Project Title: Chick-fil-A at Gibson Building Permit #: _____ City Drainage #: _____

Re: **Chick-fil-A**
1600 Gibson Blvd. SE
Grading and Drainage Plan
Engineers Stamp Date 12/15/14 (M12-D015C)

Merrick & Company has reviewed the comments received on February 26, 2015 regarding the proposed Chick-fil-A located at 1600 Gibson Blvd. SE. The following summarizes Merrick's response to the comments provided by the City of Albuquerque.

SHEET TITLE
GRADING PLAN

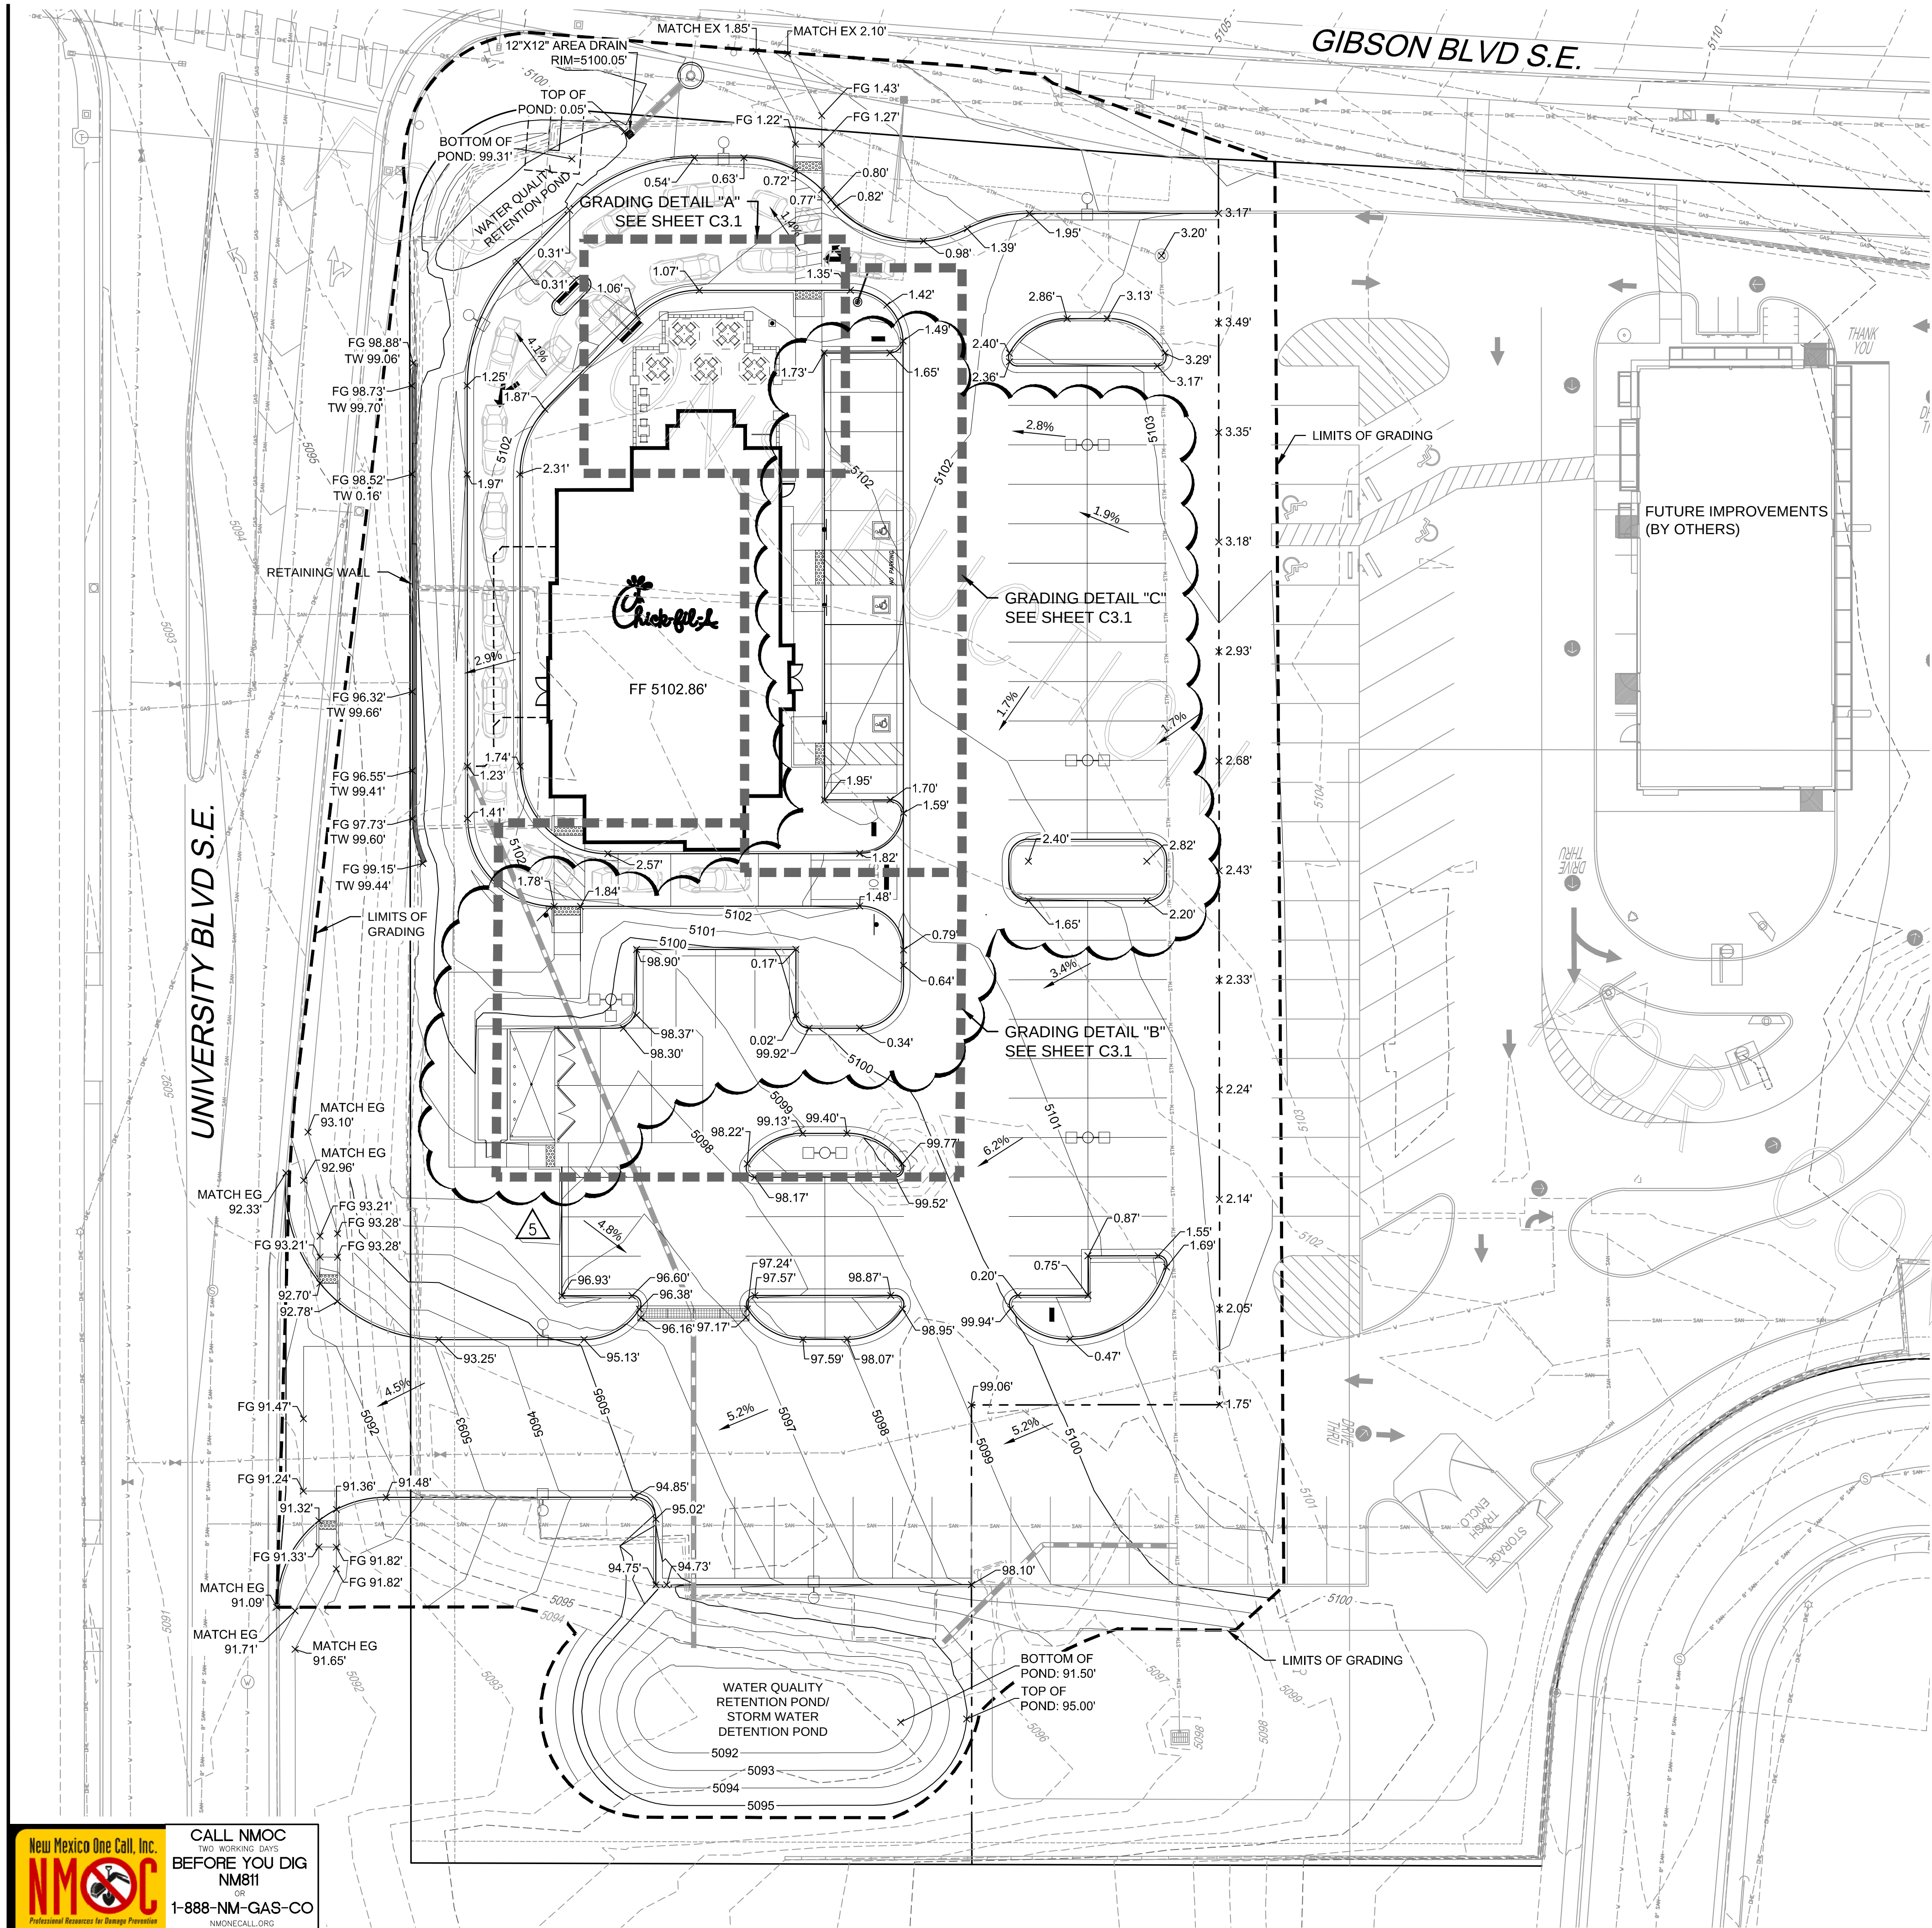
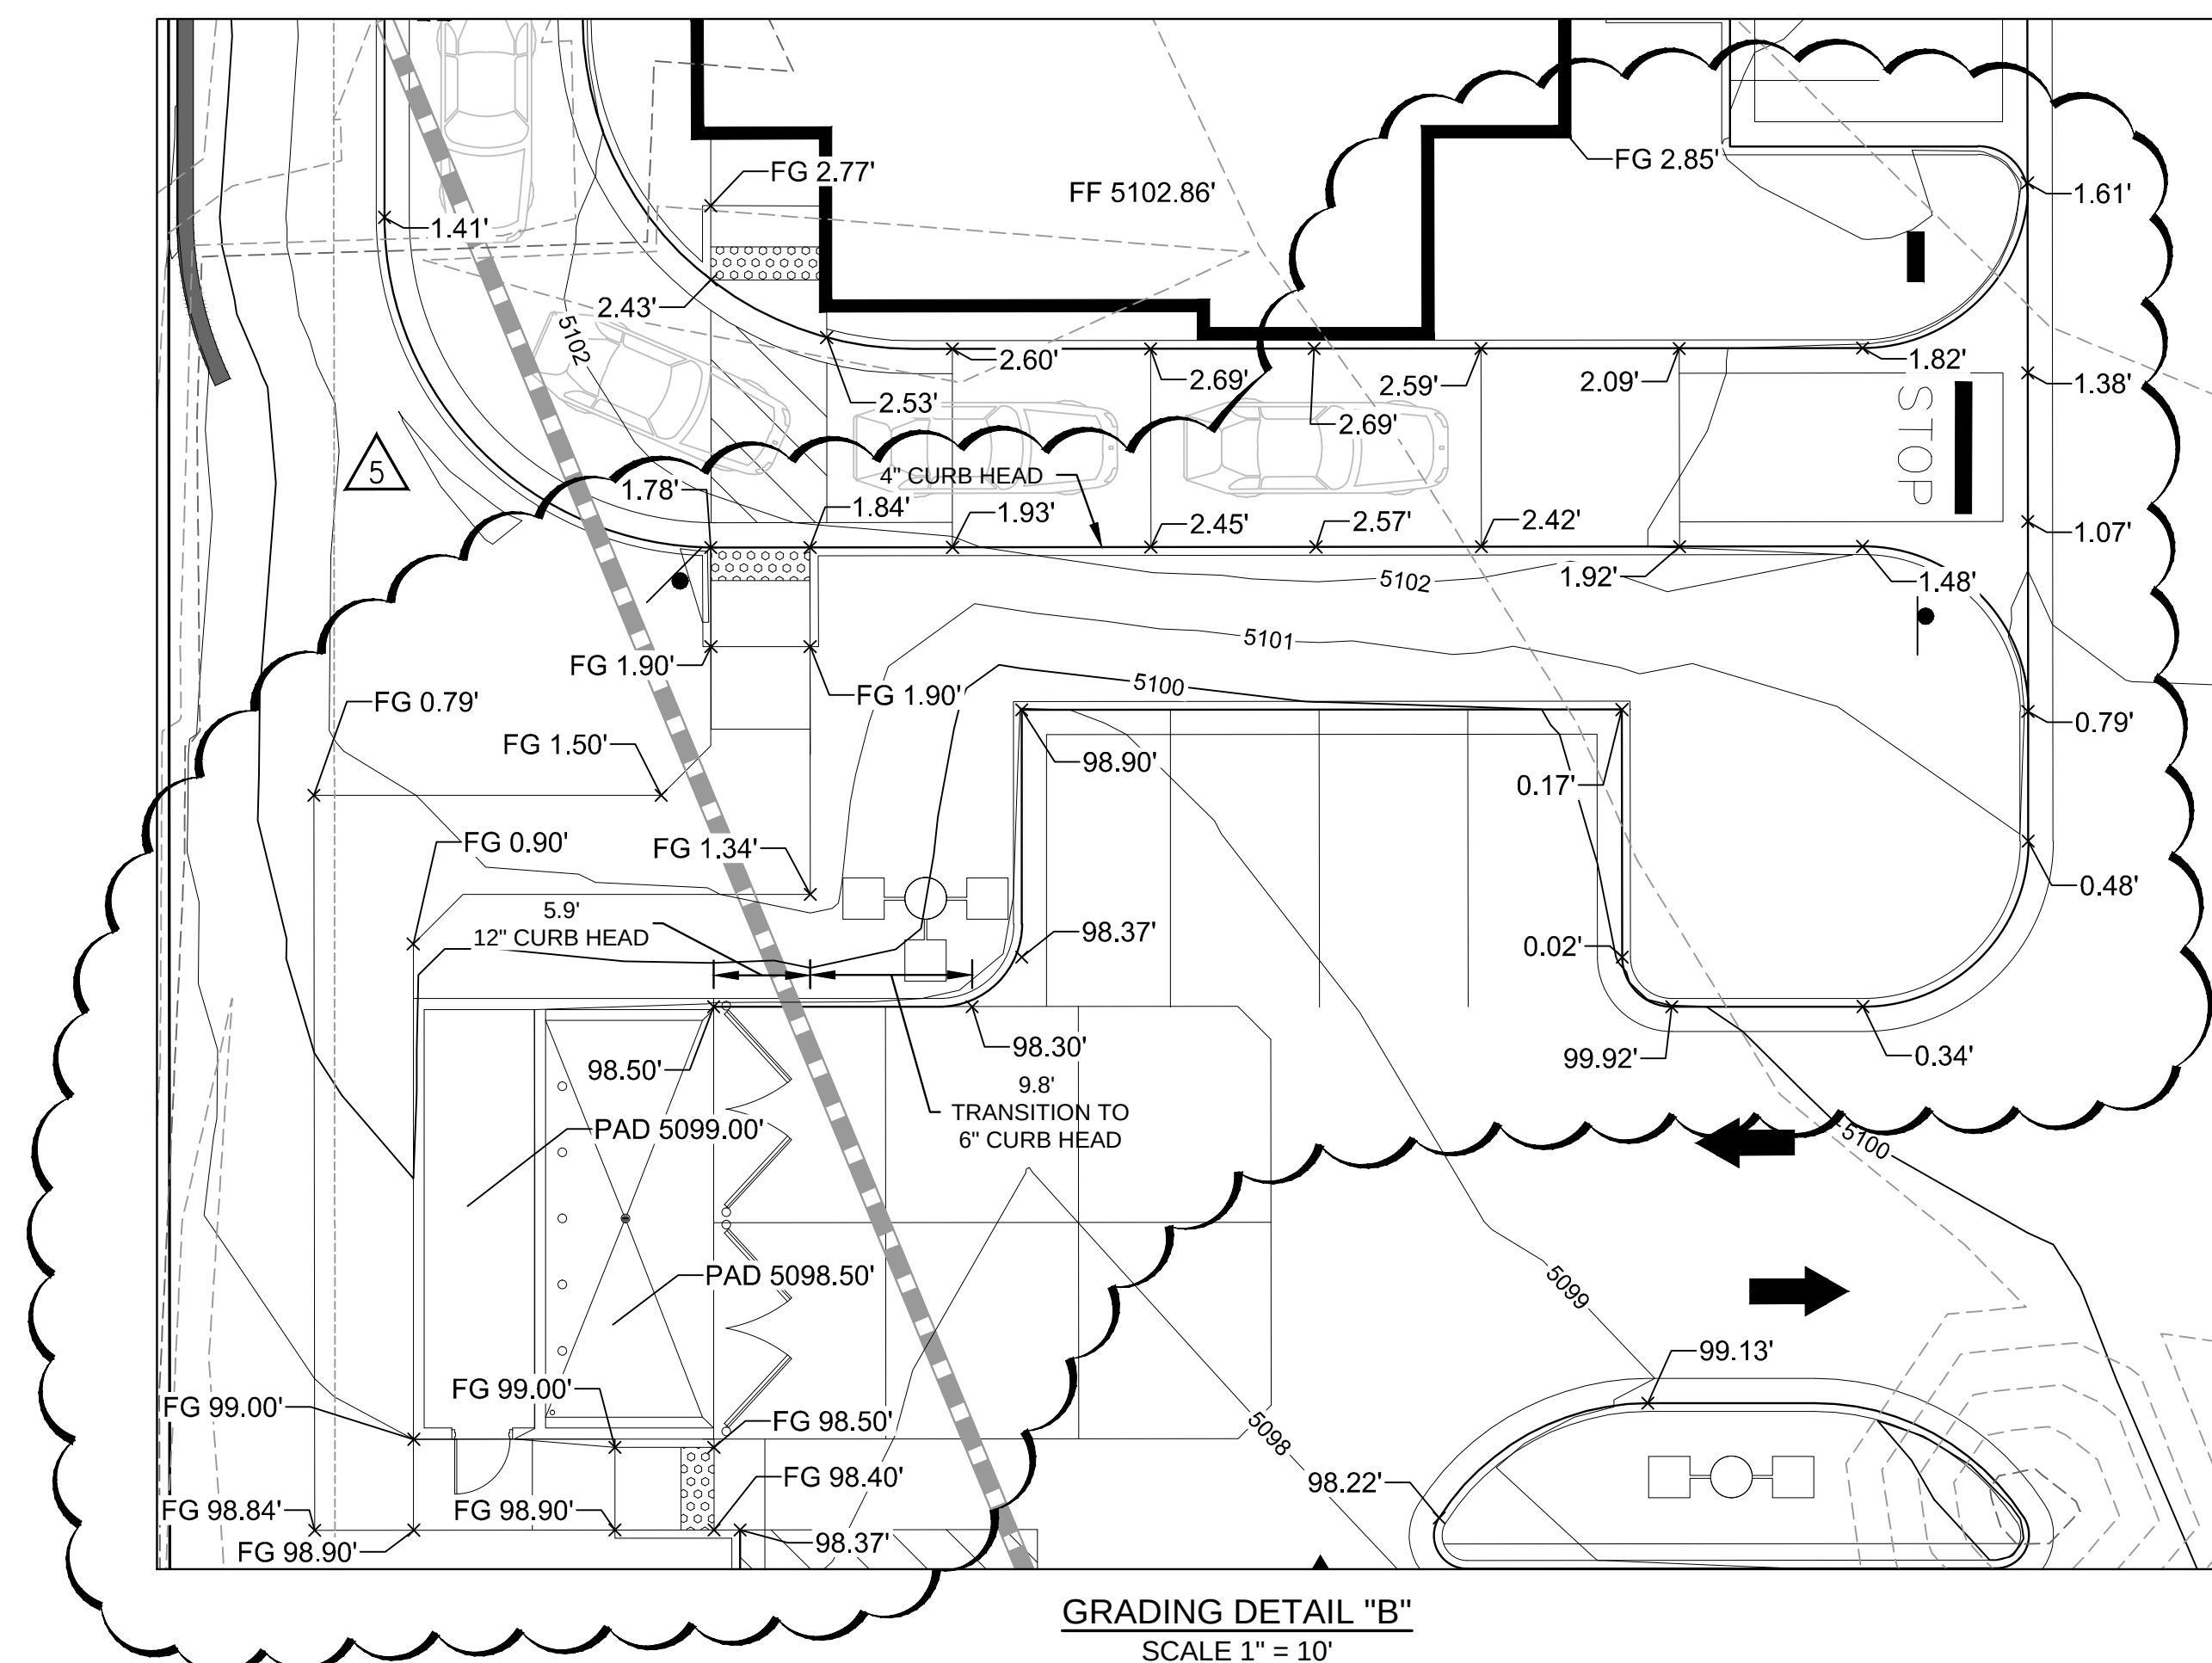
- Provide the legal description on the G&D plan along with the benchmark location.

- There appears to be a ponding area in the drive up lane.

Response: The legal description has been provided of the G&D plan along with the benchmark.

Response: The grading has been adjusted to remove ponding area.
